## ***Recommendations***

Detailed Landscape Proposals

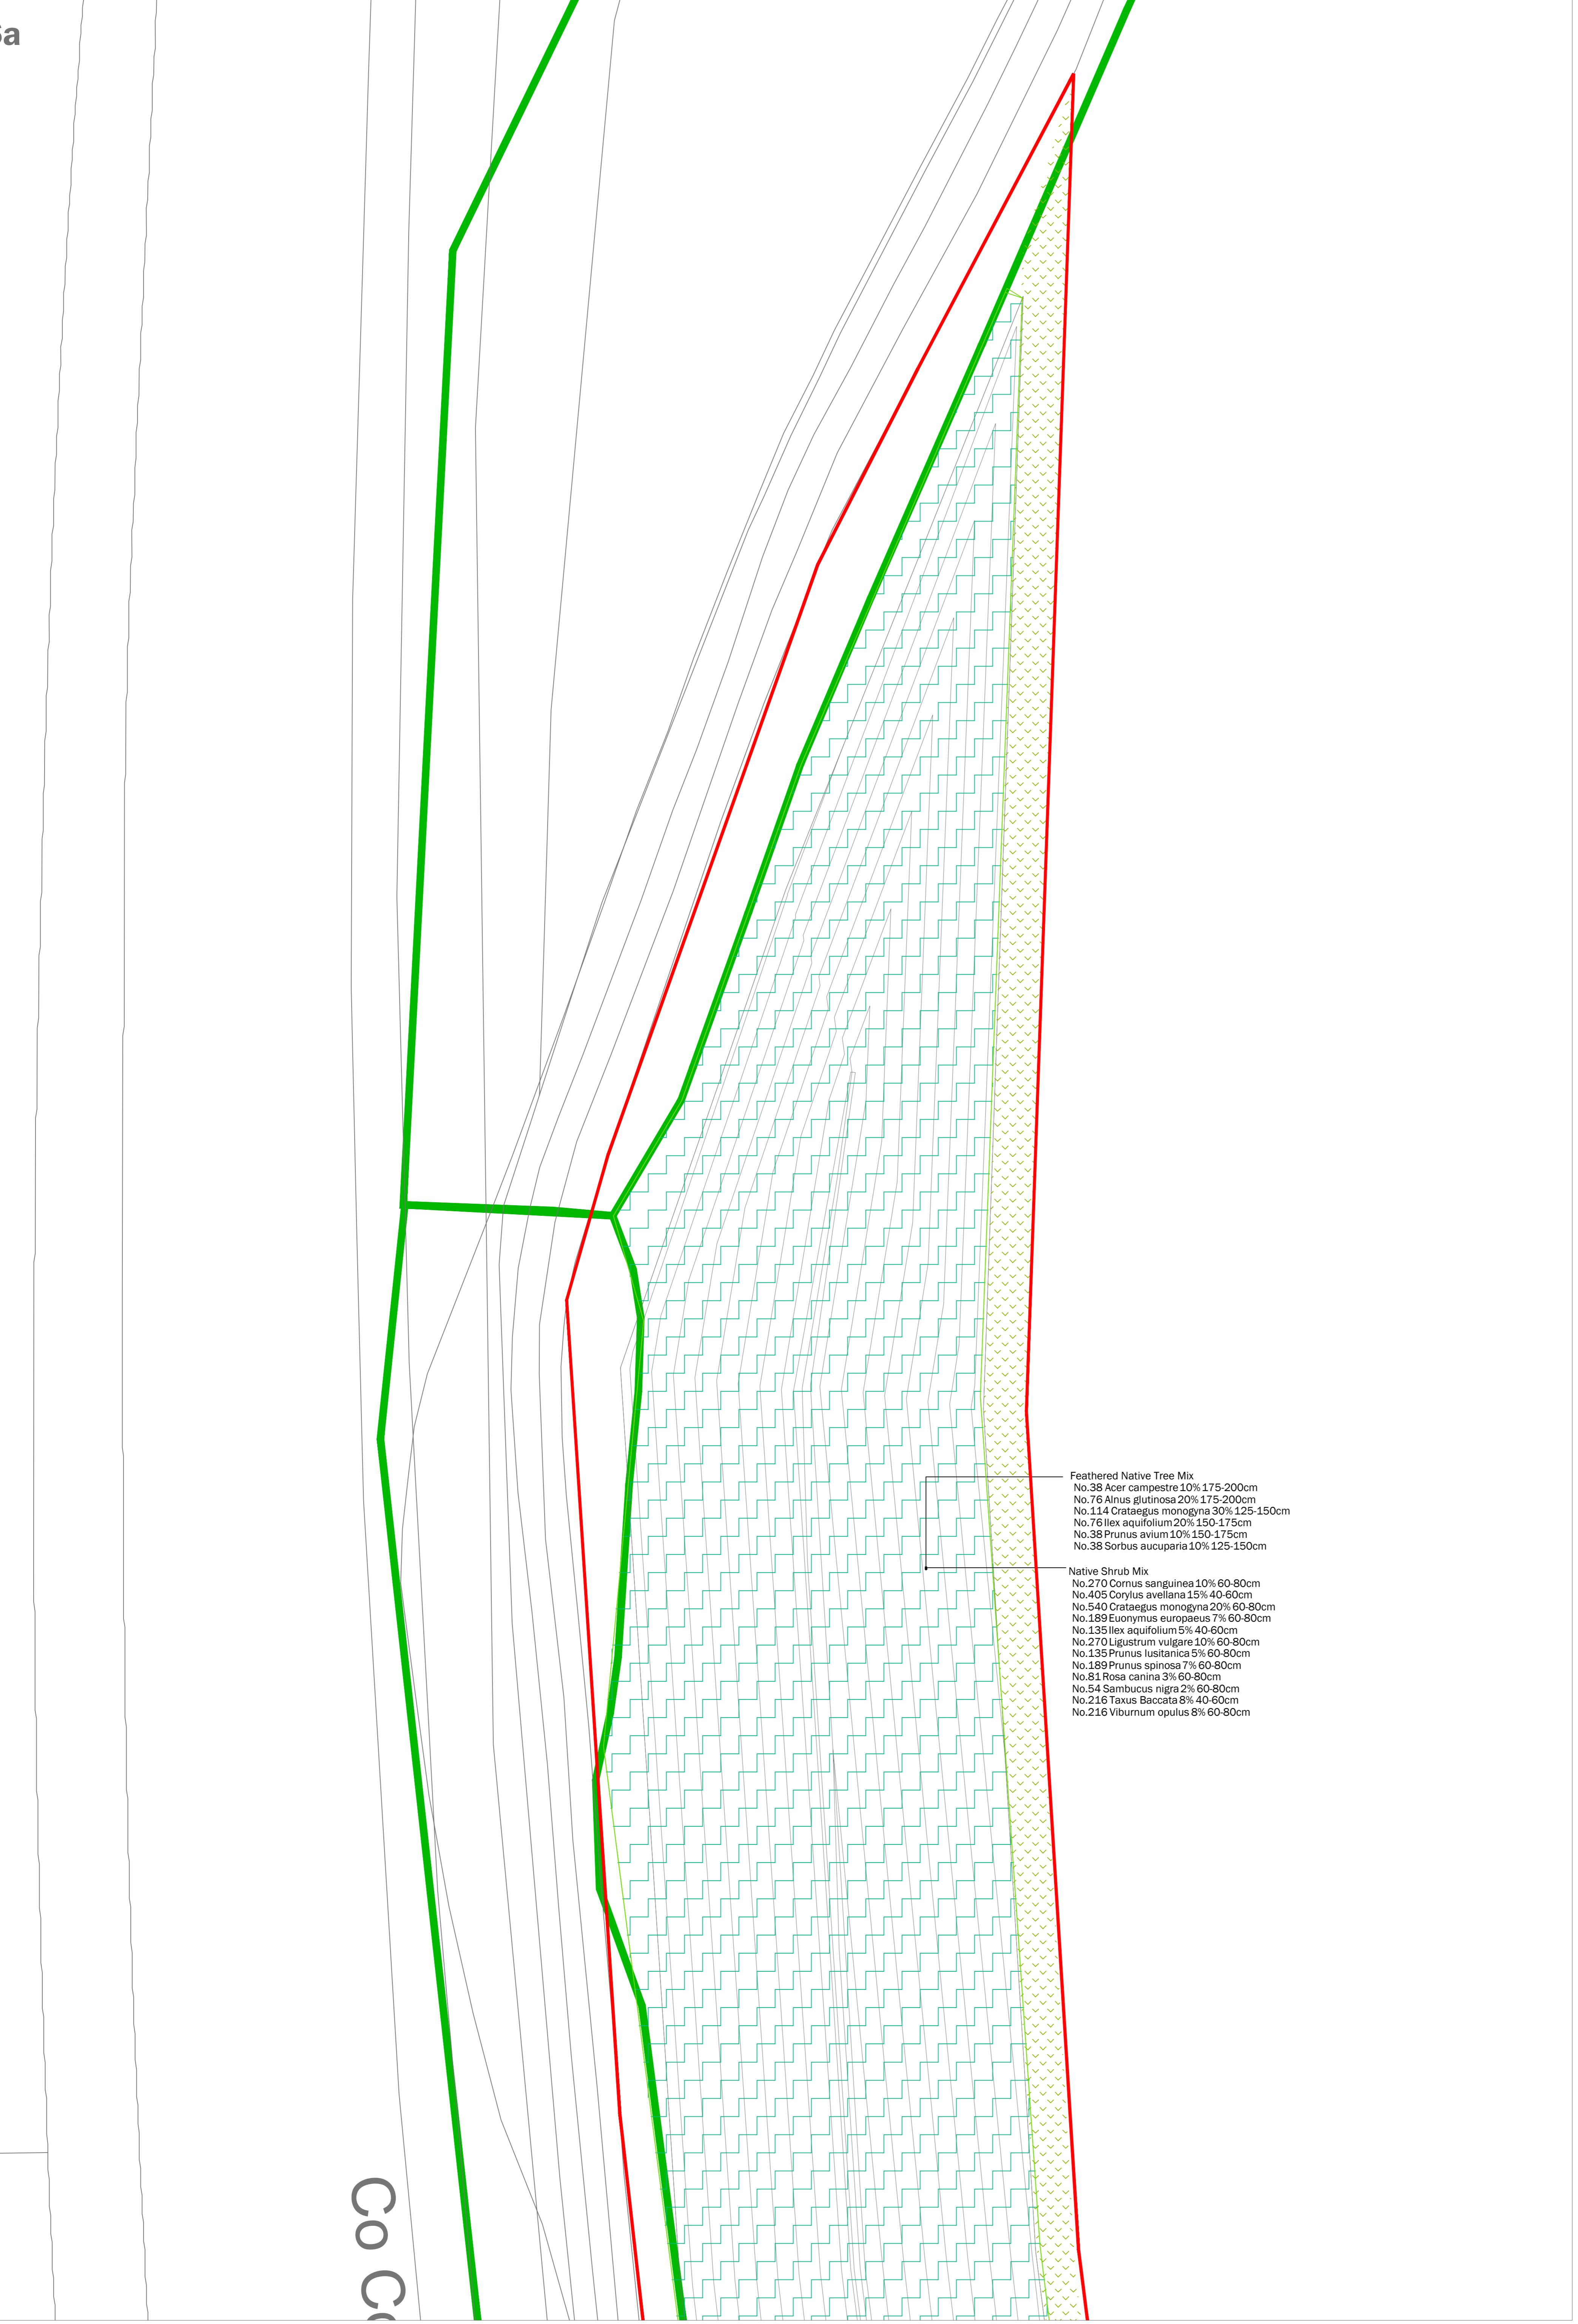
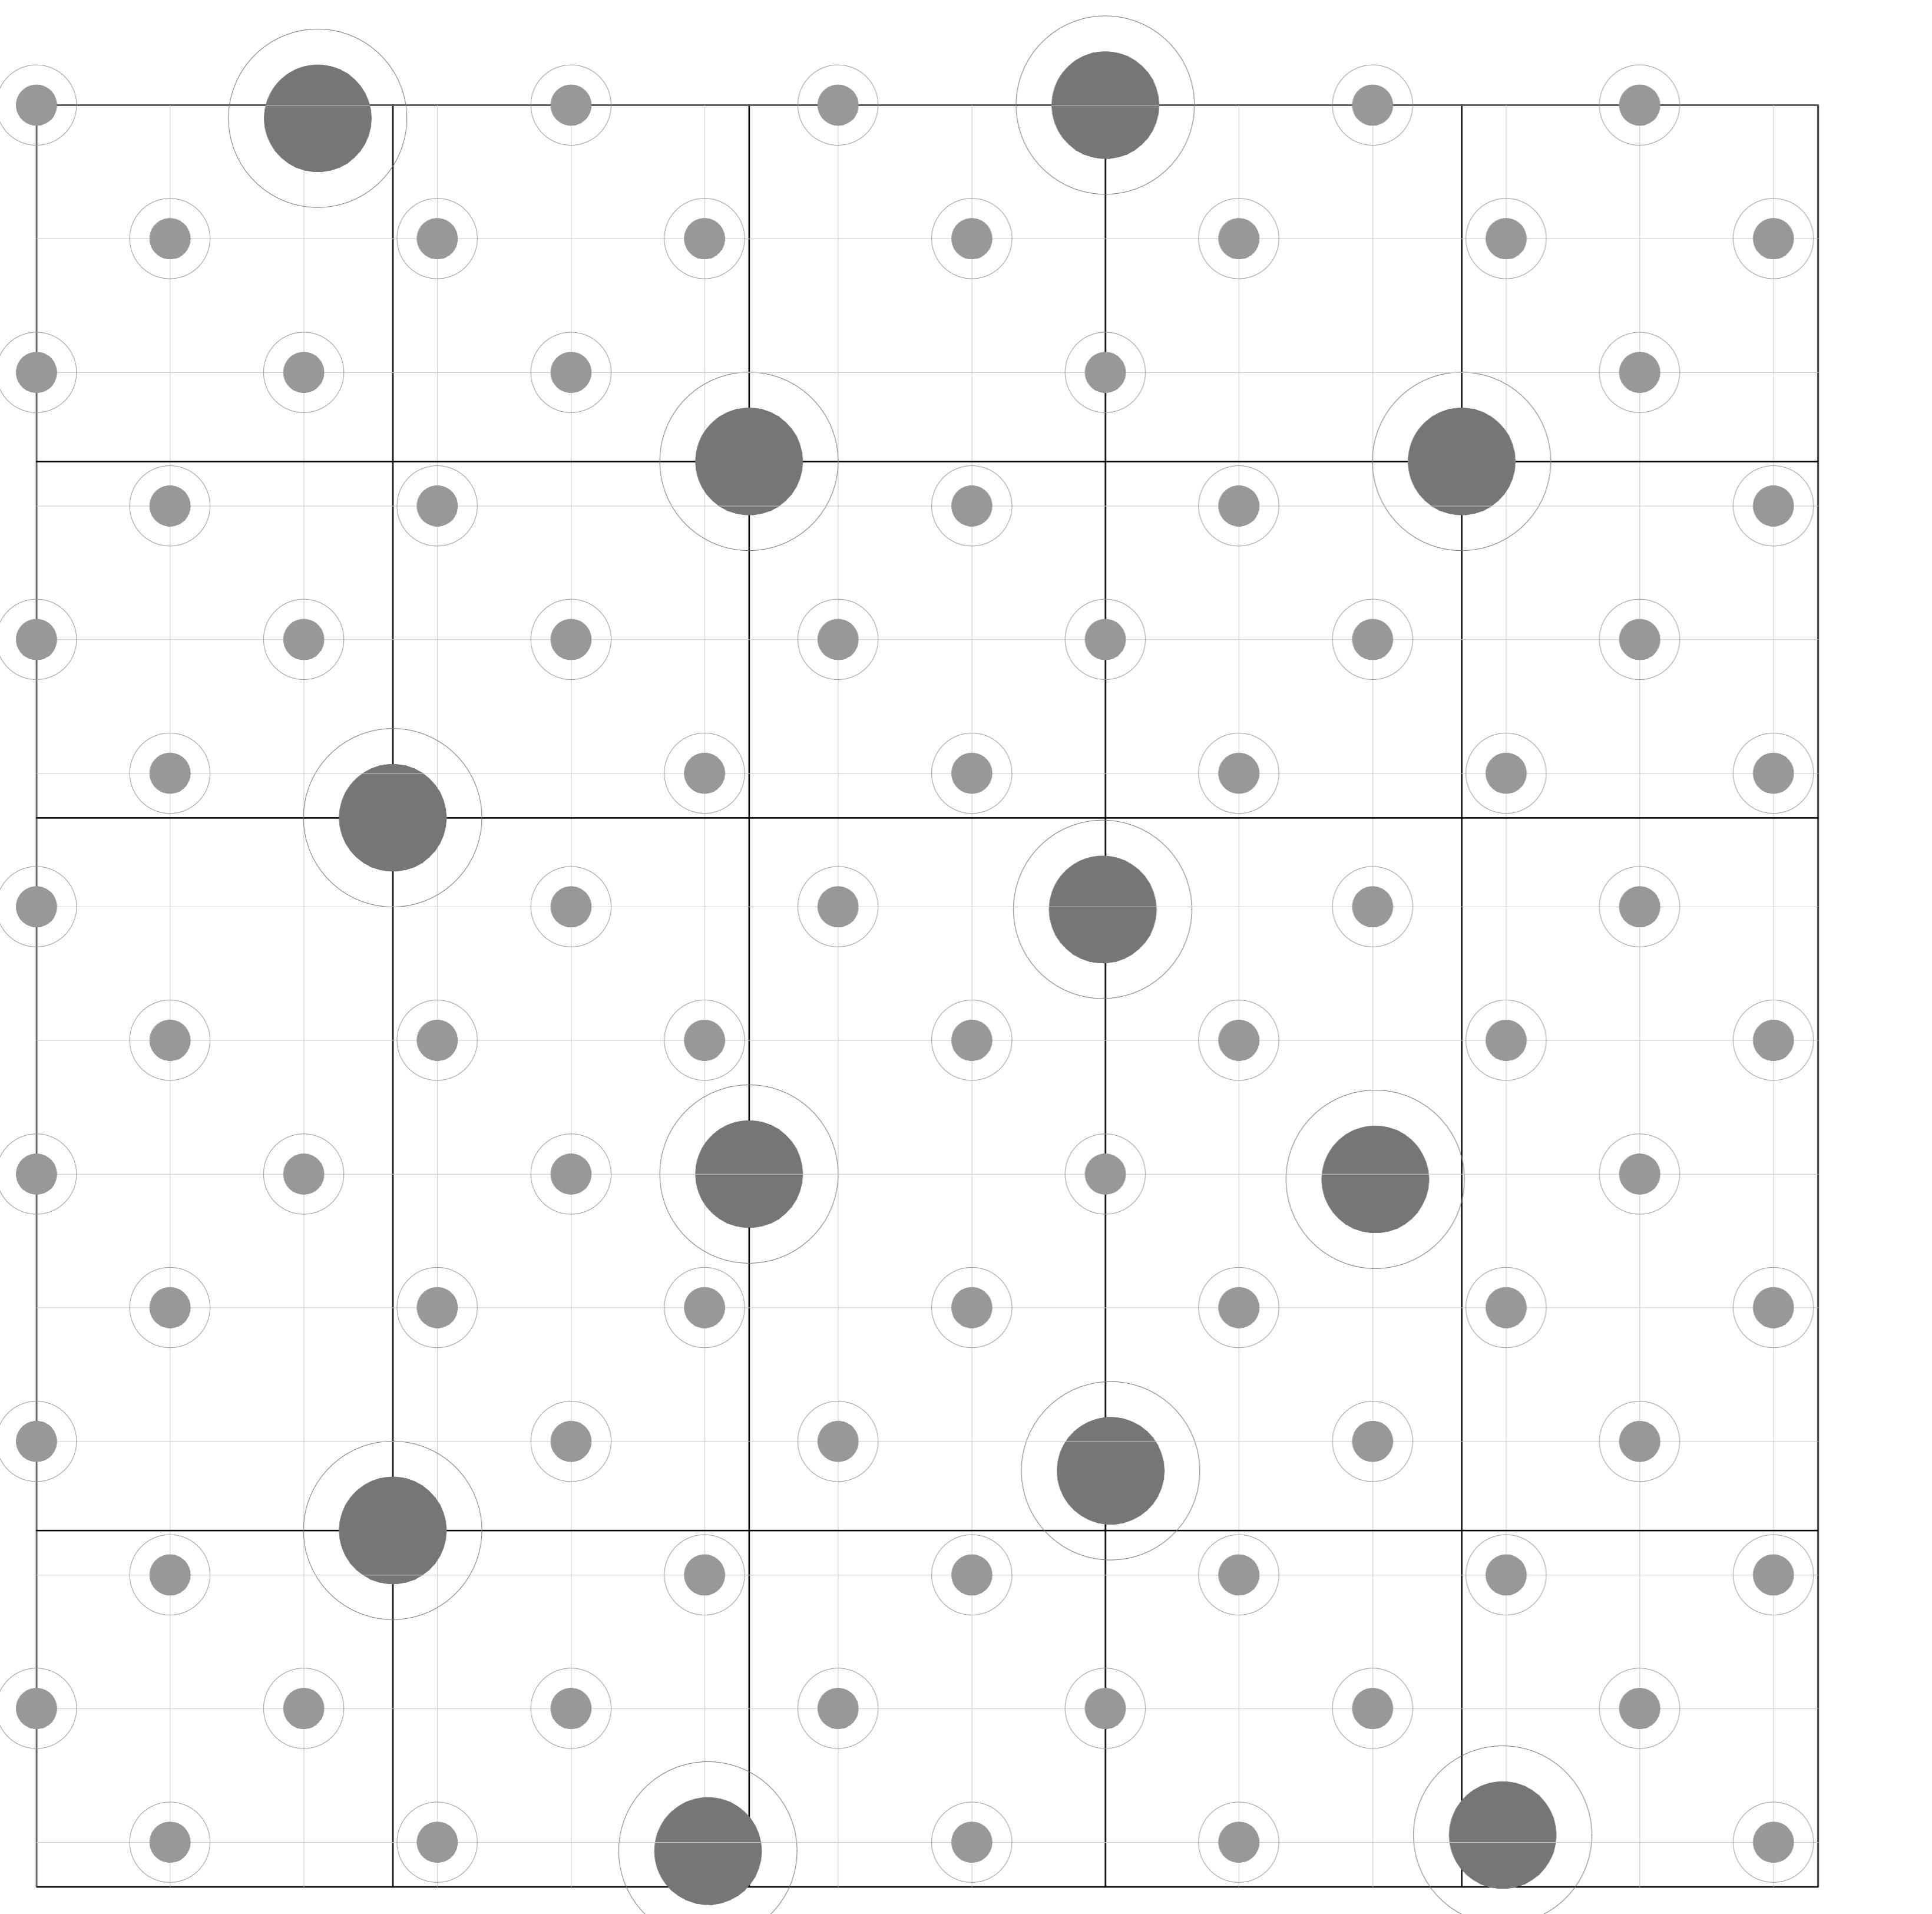
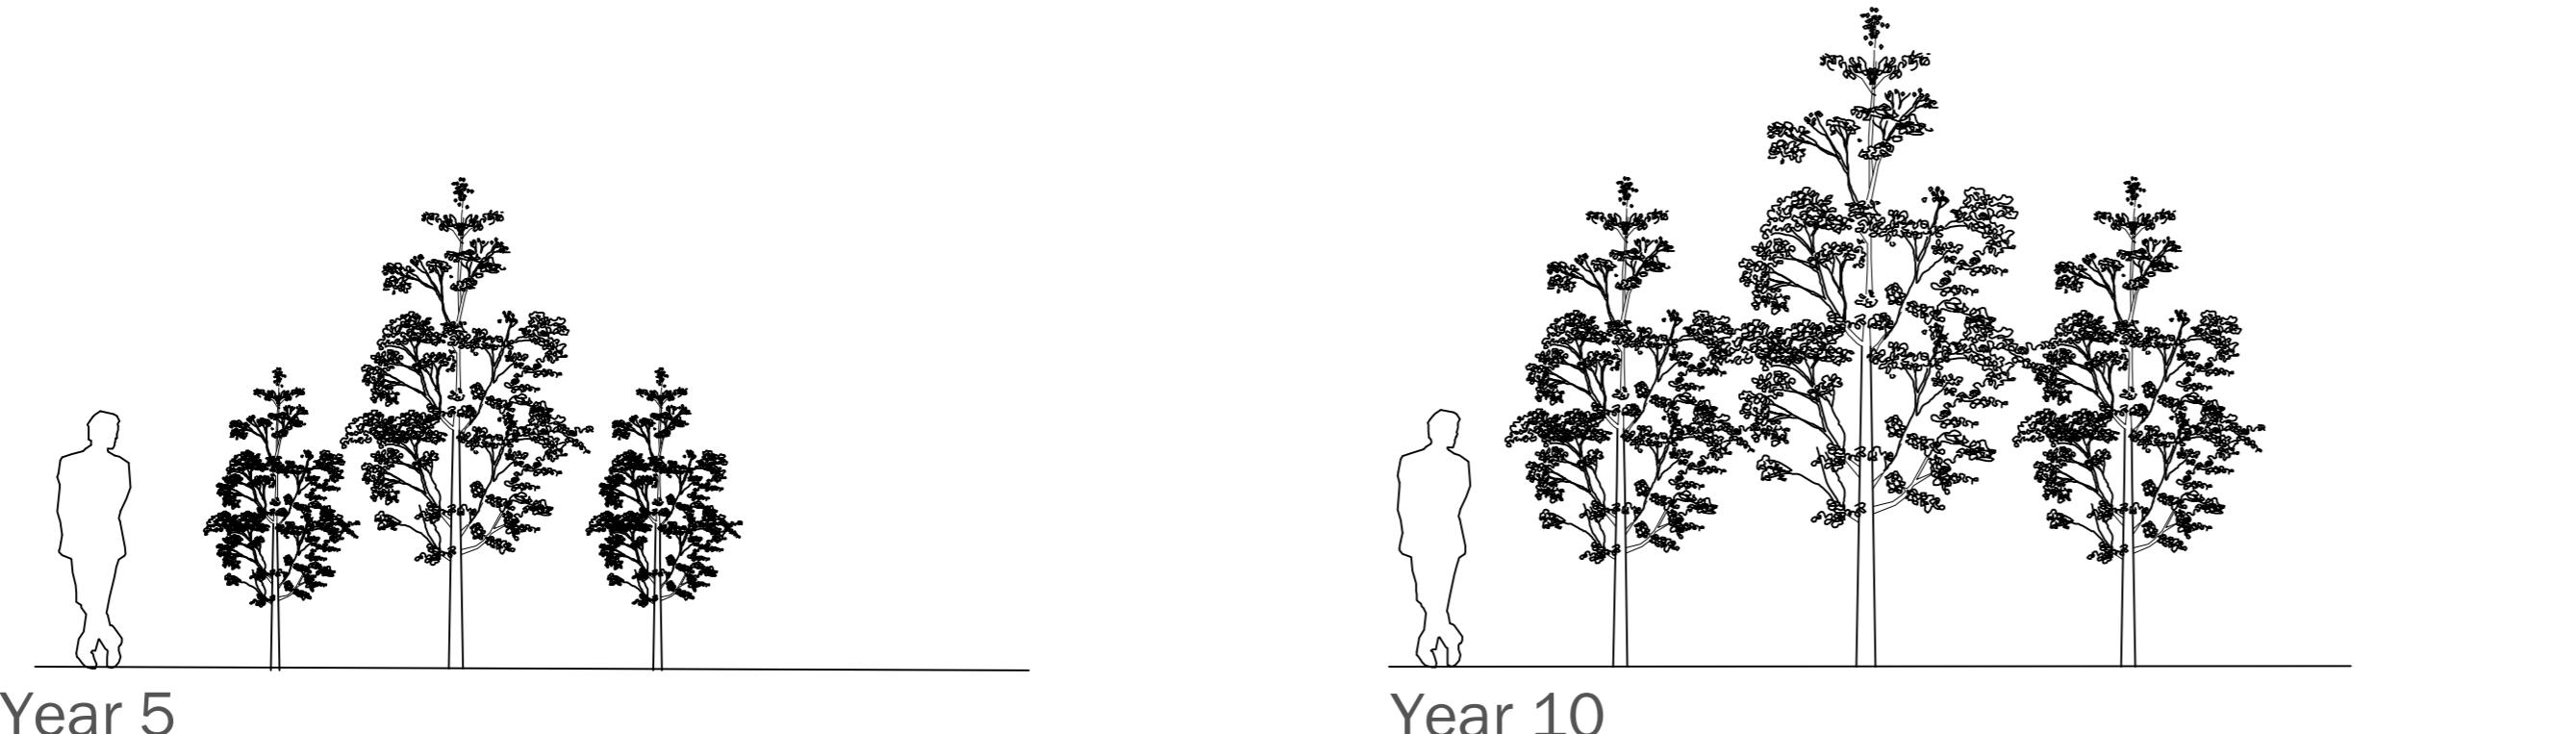
***9 - Whether the bunds will be softened to appear ‘natural’ (the bunds shown on the detailed landscape proposals in Appendix 9.4 look very ‘angular’).***

The landscape proposals have been based on detailed levels provided by engineers. The level of the bunds has been landscape-led, limiting the profile of the bunds to no steeper than 1 in 3 in order to reduce the likelihood of there being an engineered appearance. Each bund has been planted with native trees and shrubs that reflect the local context throughout the scheme to maintain a buffer to the wider setting.
